# CITY OF ALBUQUERQUE

April 30, 2024

**Re: Touro College of Dental Medicine/ Tenant Improvements**  
**2425 Ridgecrest Dr. SE**  
**Traffic Circulation Layout**  
Architect's Stamp 04-10-24 (M18-D006)

## A1 TRAFFIC CIRCULATION LAYOUT: ON-SITE

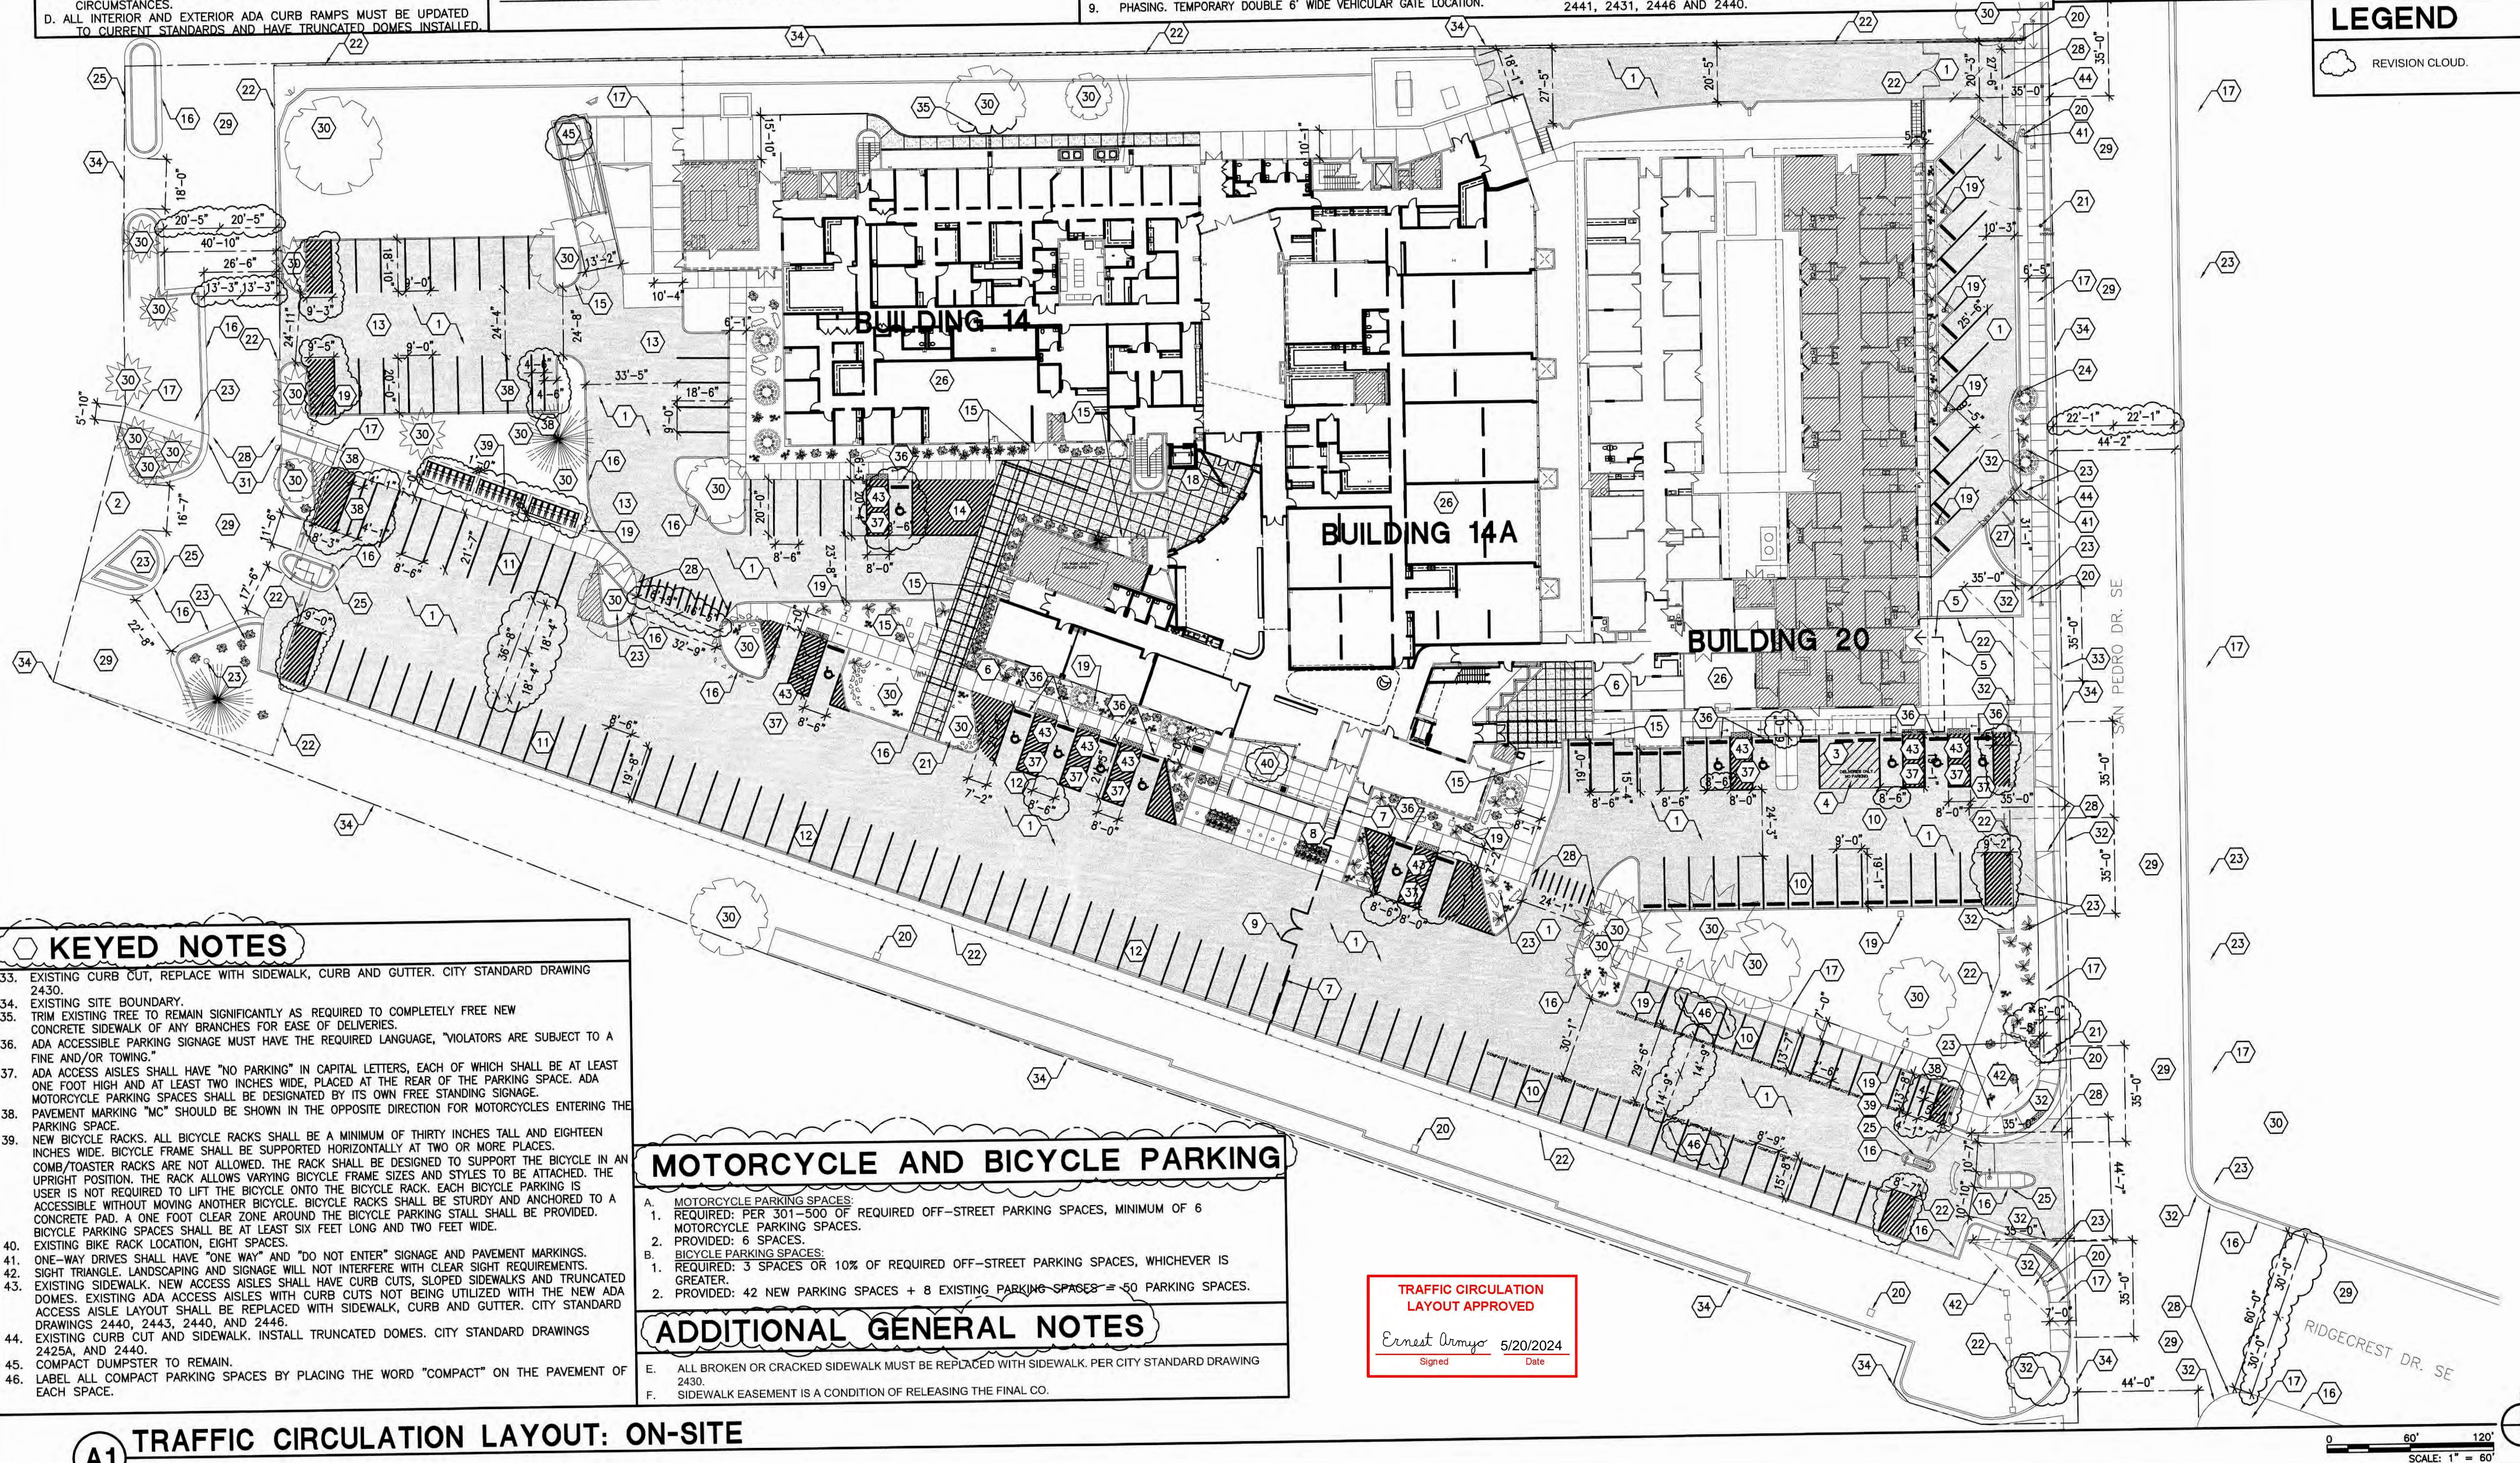
25. Please specify the City Standard Drawing Number when applicable.
26. Key note 17 in sheet TCL-101 and keynote 2 in sheet TCL-102: Add a note stating "All broken or cracked sidewalk must be replaced with sidewalk and curb & gutter." A build note must be provided referring to the appropriate City Standard drawing.
